Subject: A/55/19/PL

With regard to the application I would like to make two observations aimed at avoiding irreversible mistakes and damage to protected Local Green Space.

Street Elevation (1:200)

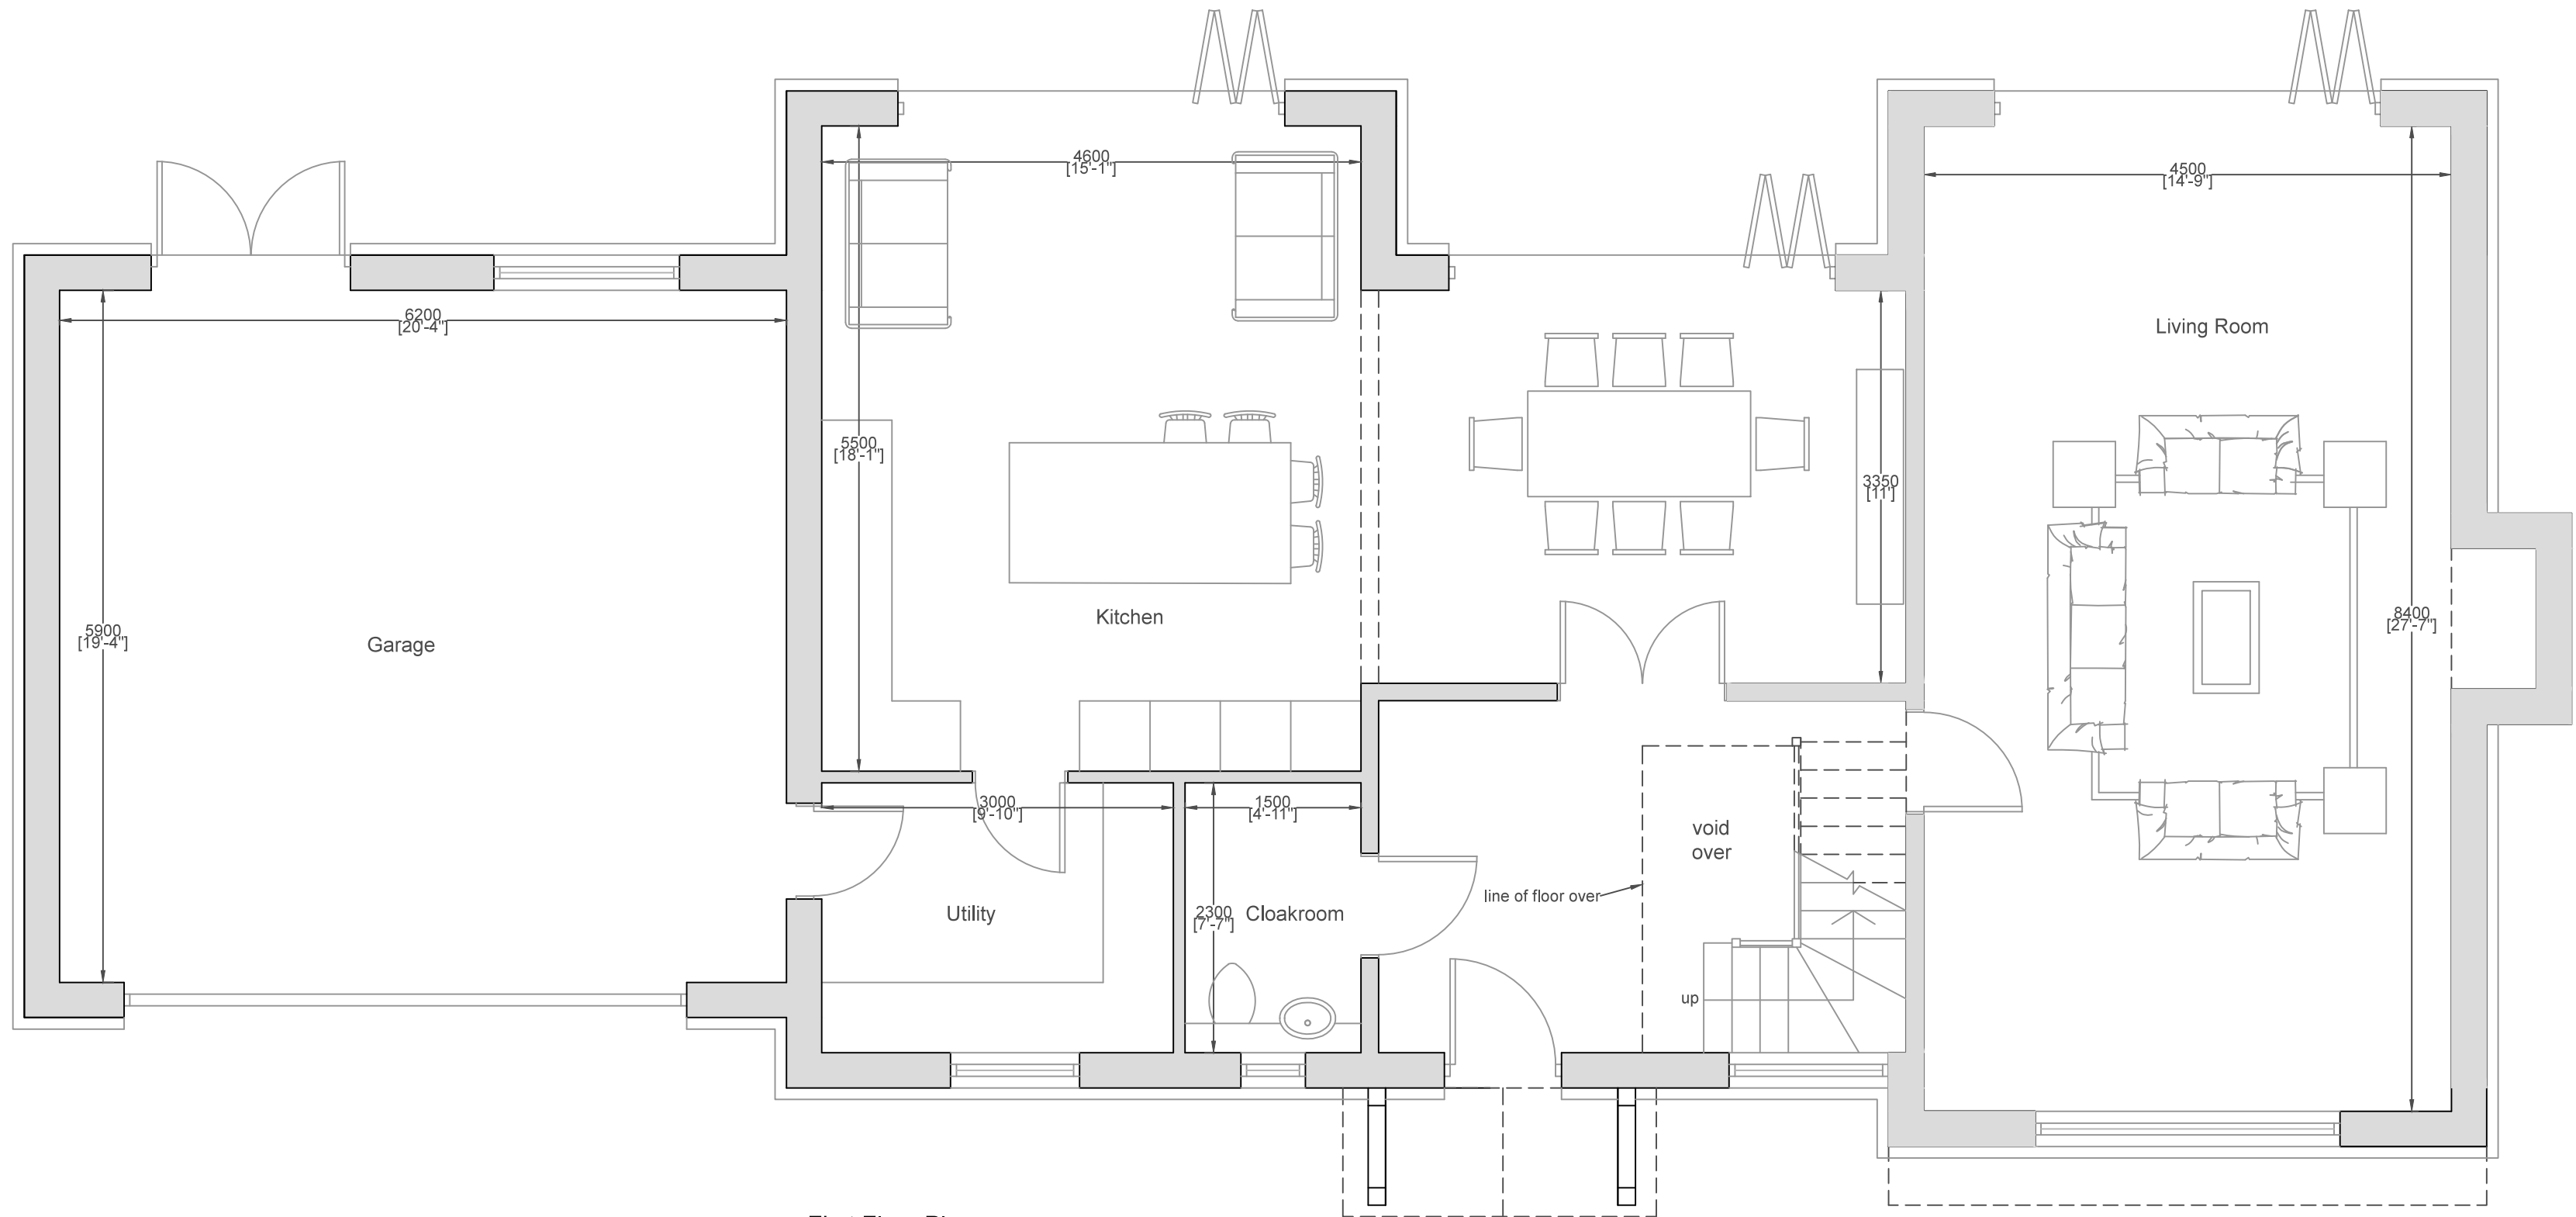
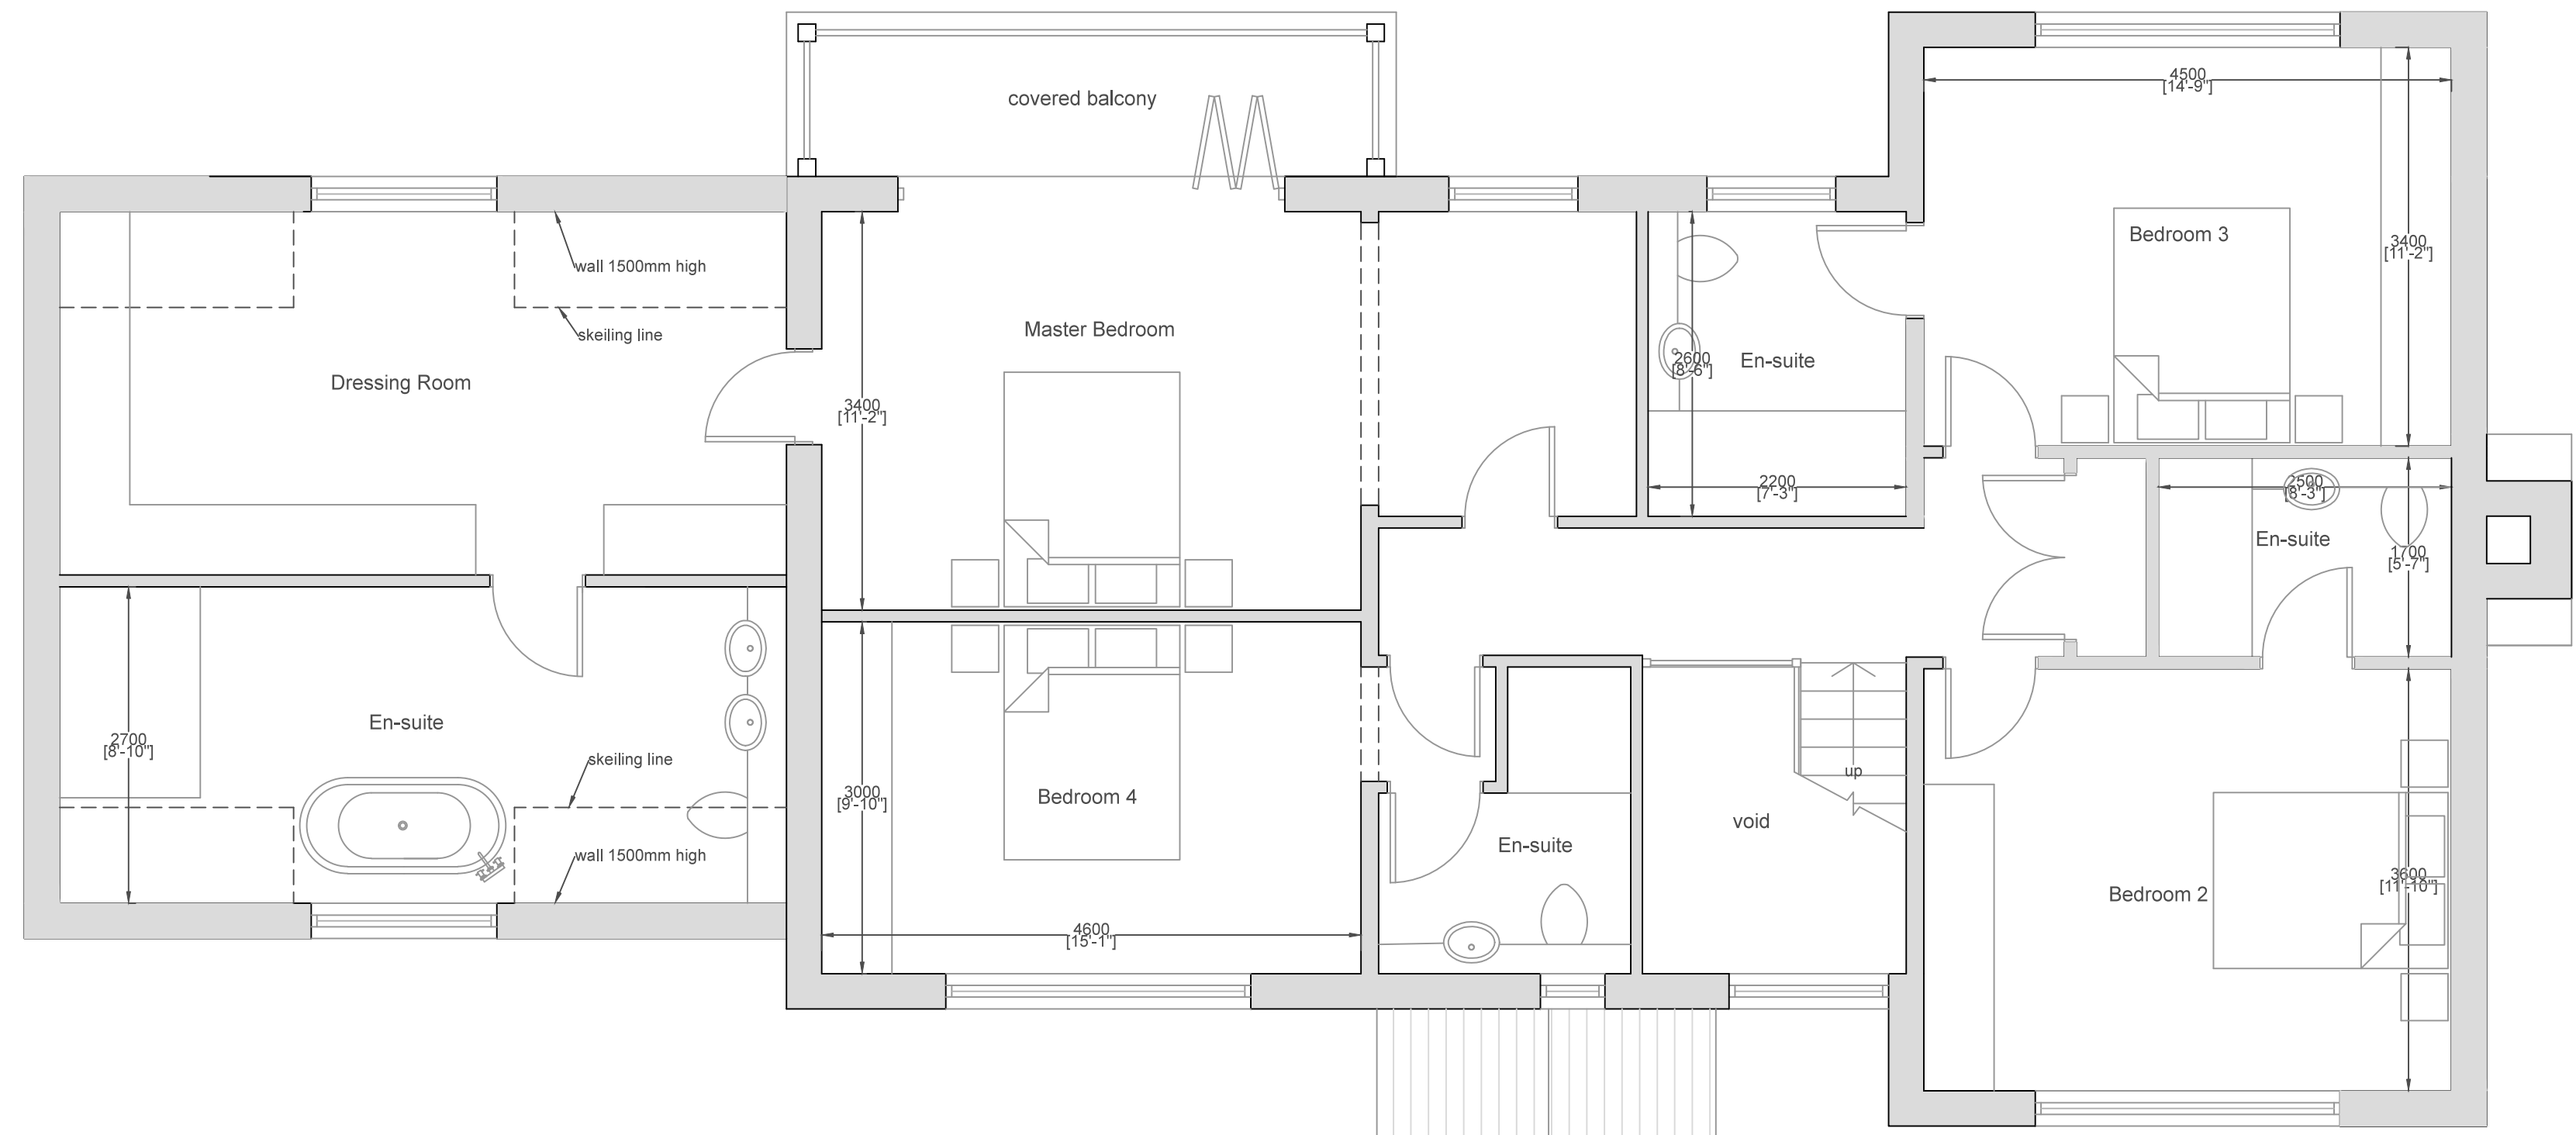
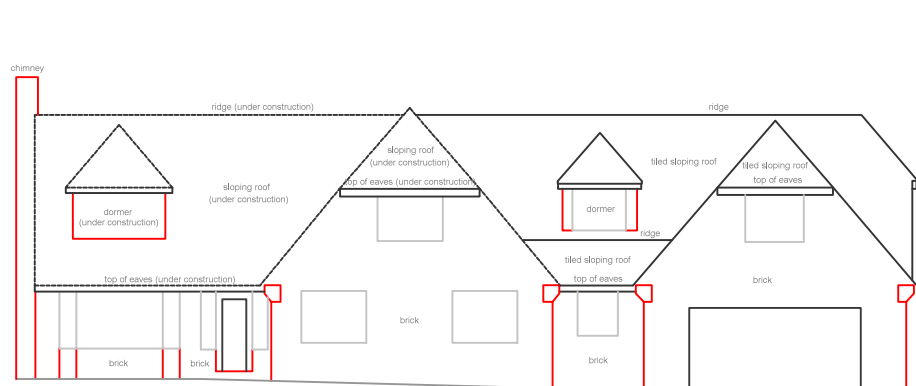
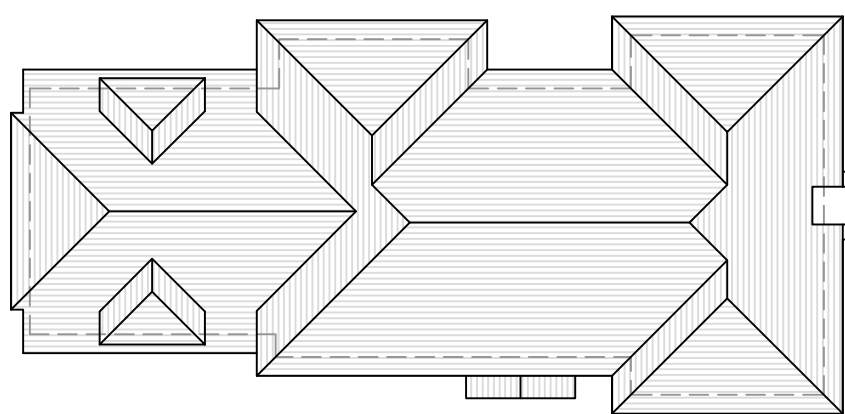
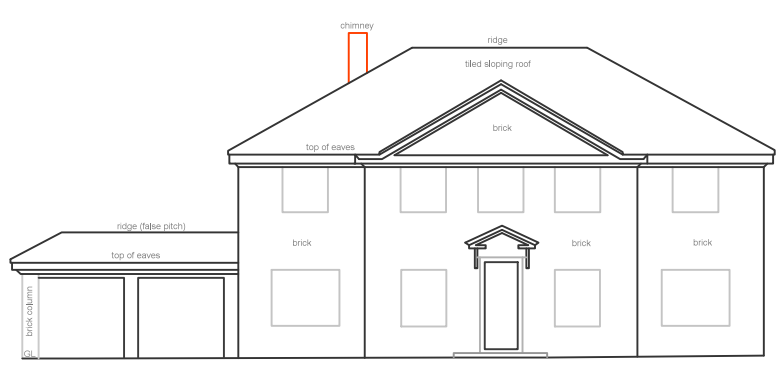
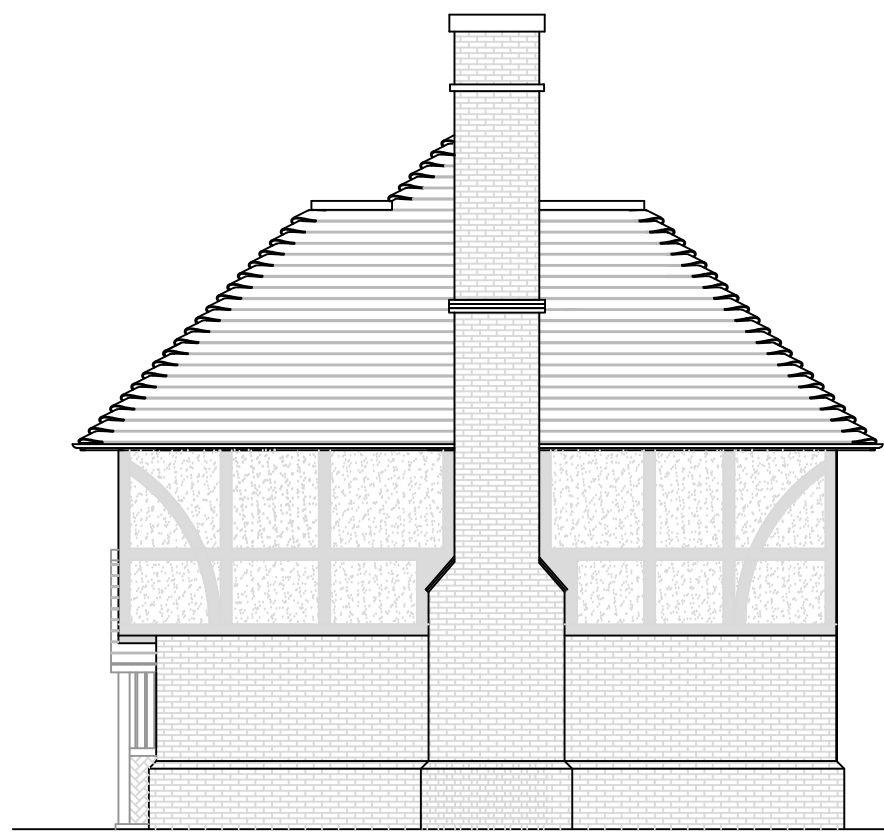
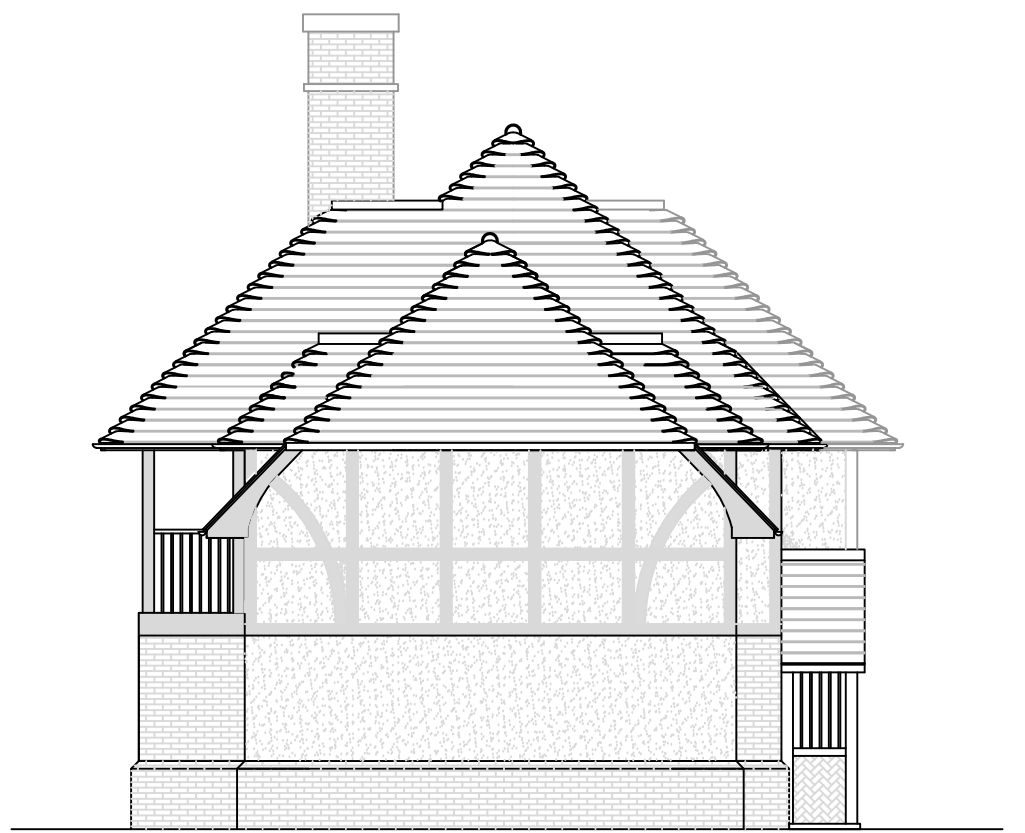
Ham Manor Way does benefit from a range and style of properties but in the immediate area to A/55/19/PL the housing is characterised by chalet bungalows. Any development in this area should therefore follow the street scene and character of the area, under appropriate Arun and Angmering policies, and be chalet type properties.

It is worth again being mindful of The Inspector's comments where he stated that a scheme under the fallback would be contained in a more natural and considered line to reflect the established pattern of existing development, and create a permeable and more open grain of development. The proposal in A/55/19/PL puts a large house in the middle of the present open space on plot 9 which virtually fills the whole plot - or is greater than the narrowing proton the basis of the evidence in part a). Plot 8 is retained for future development. Even the house on plot 9 appears to go against The Inspector's guidance and a further property on plot 8 certainly would compound the situation creating a continuous built form against the open rural aspect of the area.
